TS/GK
15031
19 August 2016

**SECTION 75W MODIFICATION APPLICATION TO MAJOR PROJECT APPROVAL MP10_0219
1, 1A & 5 AVON ROAD, 4 & 8 BEECHWORTH ROAD, PYMBLE**

DRAWING TITLE			
HERITAGE _ PROPOSED LOWER LEVEL			
SCALE	DATE	DRAWN	CHECKED
1:200 @ A3	01.11.2012	PS	JB
JOB	DRAWING	REVISION	
12009	MP 52.04	W

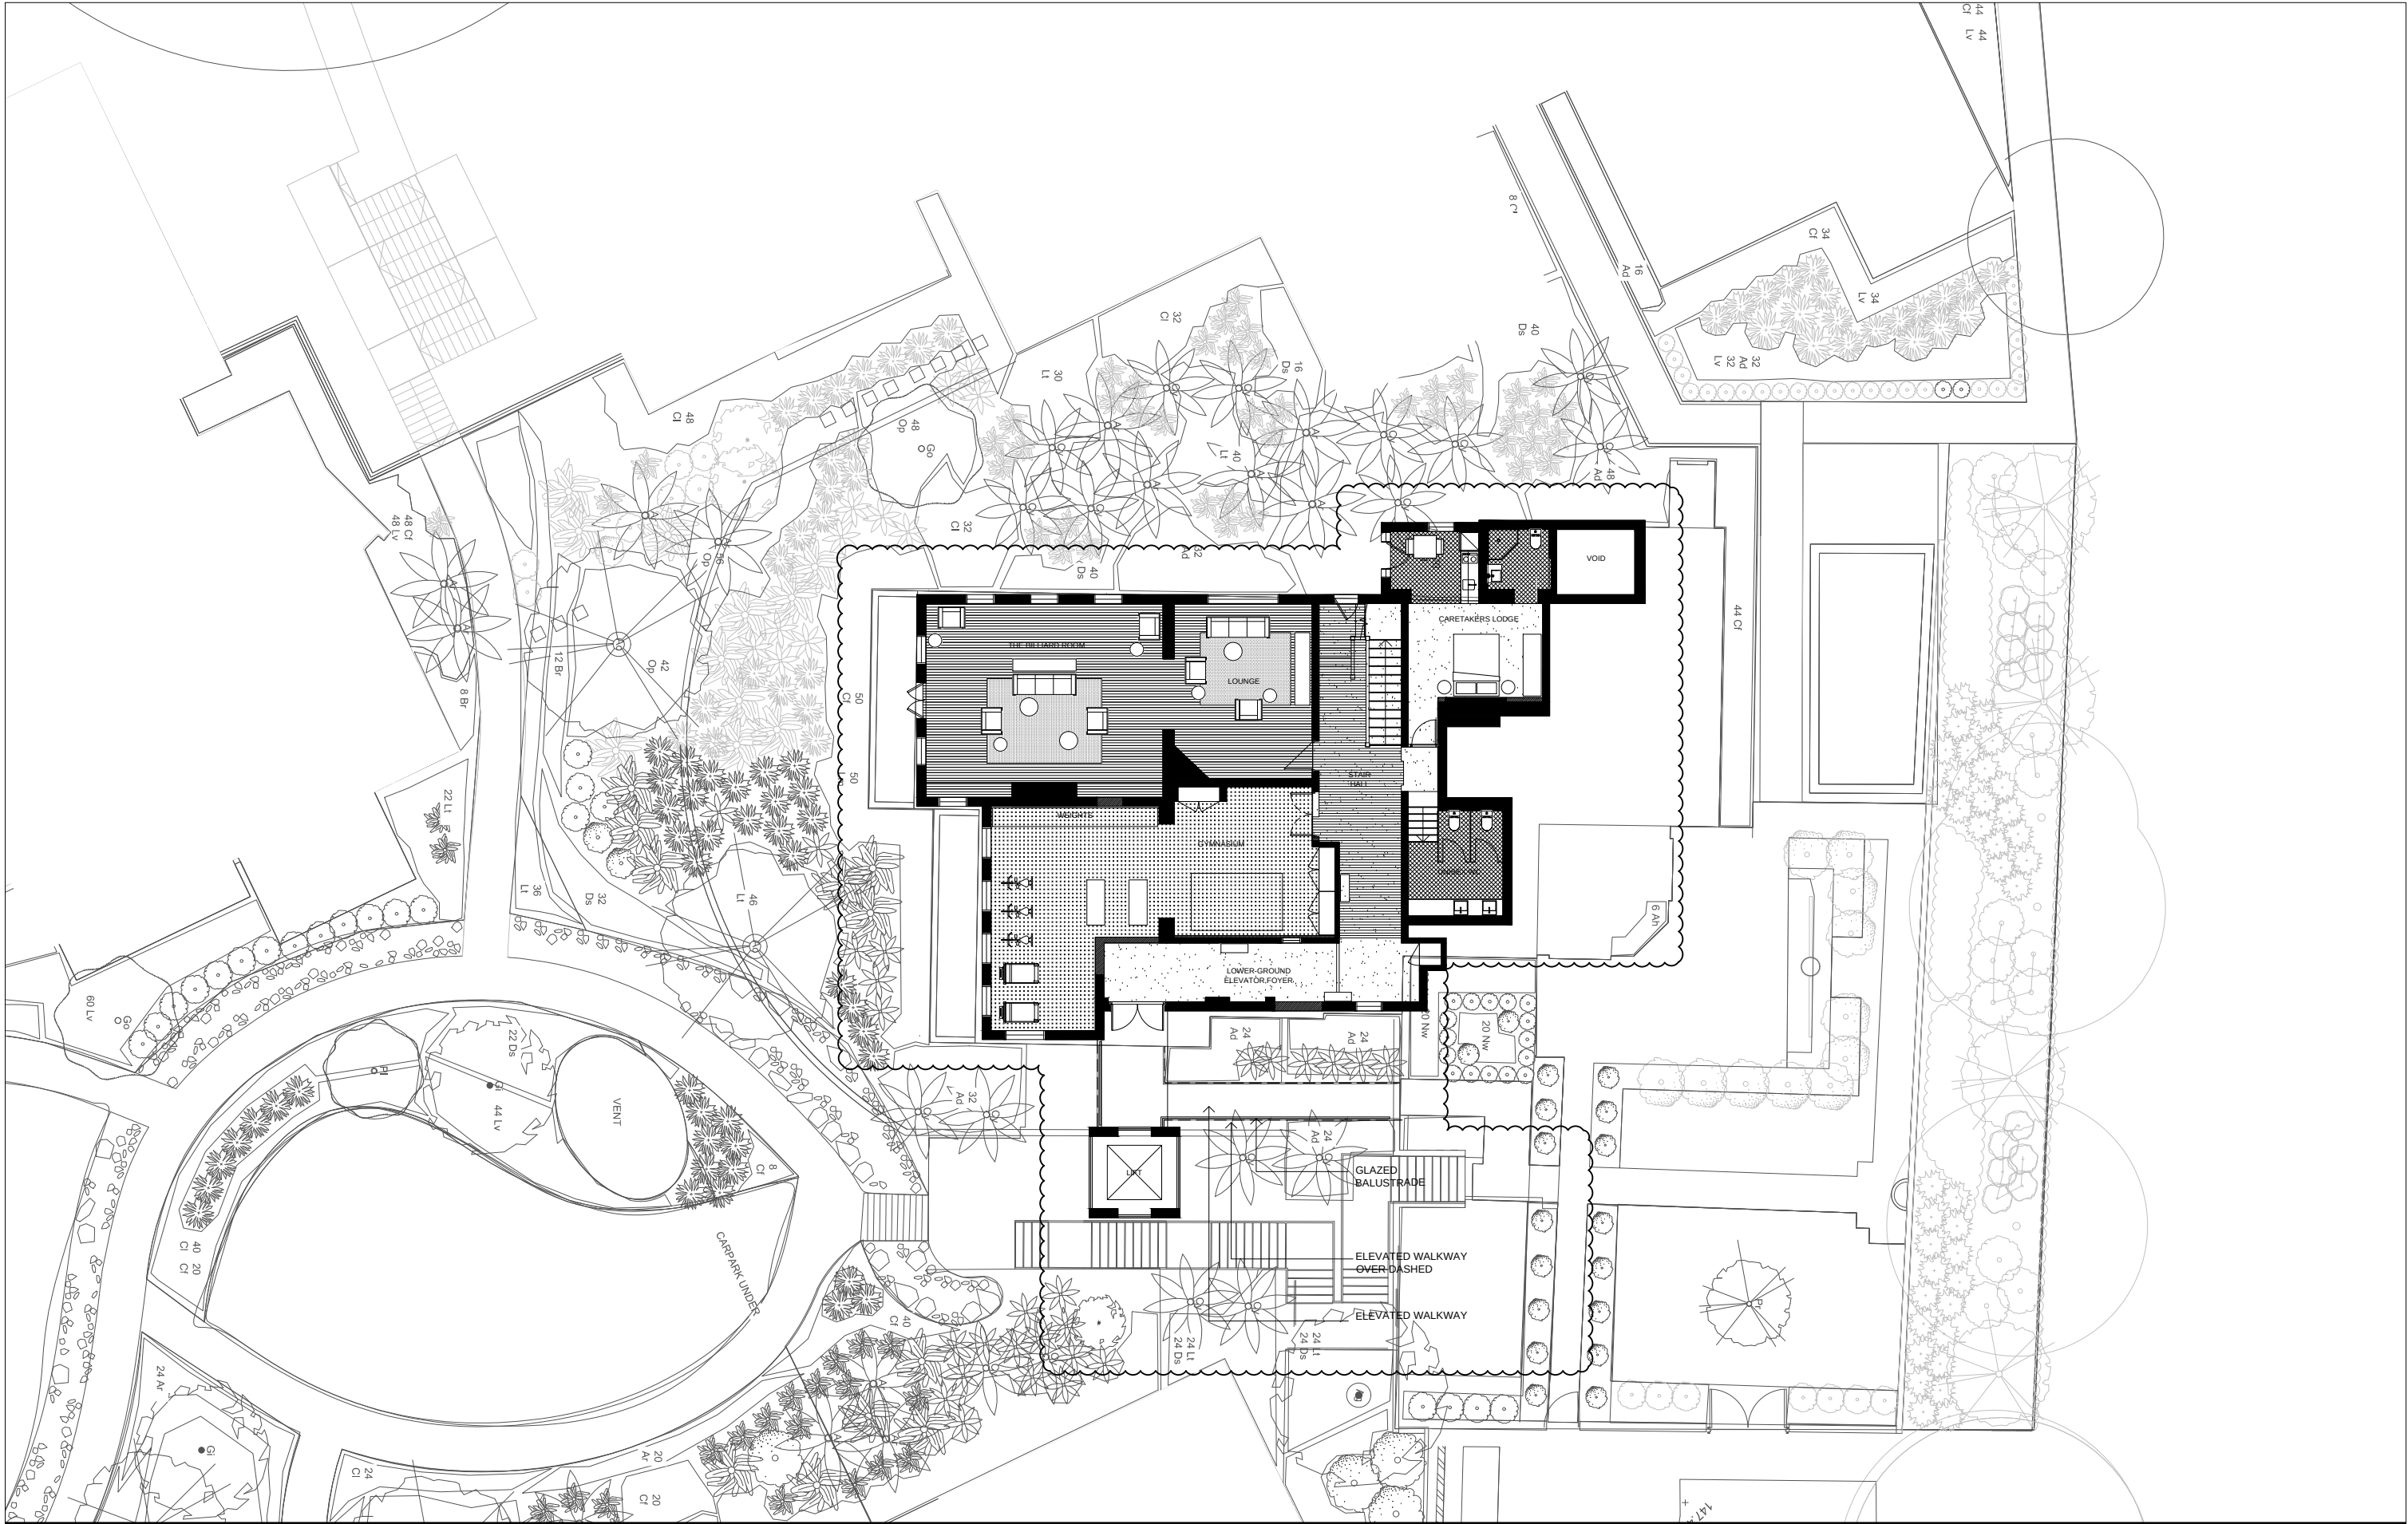
- **Rationalisation of Lifts around 1 Avon Road** – The approved development currently includes the provision of two lifts adjacent to 1 Avon Road, comprising one lift within the building and one adjacent to the building. The second approved lift is excess to requirements, accordingly has been reconfigured in such a manner that the outdoor lift can perform both roles.

The proposed development includes changes to the lift access arrangements to the communal heritage building at 1 Avon Road. Namely, the proposal intends to remove the existing duplicated lift within the heritage building, and use minor design changes to connect the lower and upper floors of the communal building with the external lift to the east of 1 Avon Road. The revised layout has been depicted below at **Figure 2**.
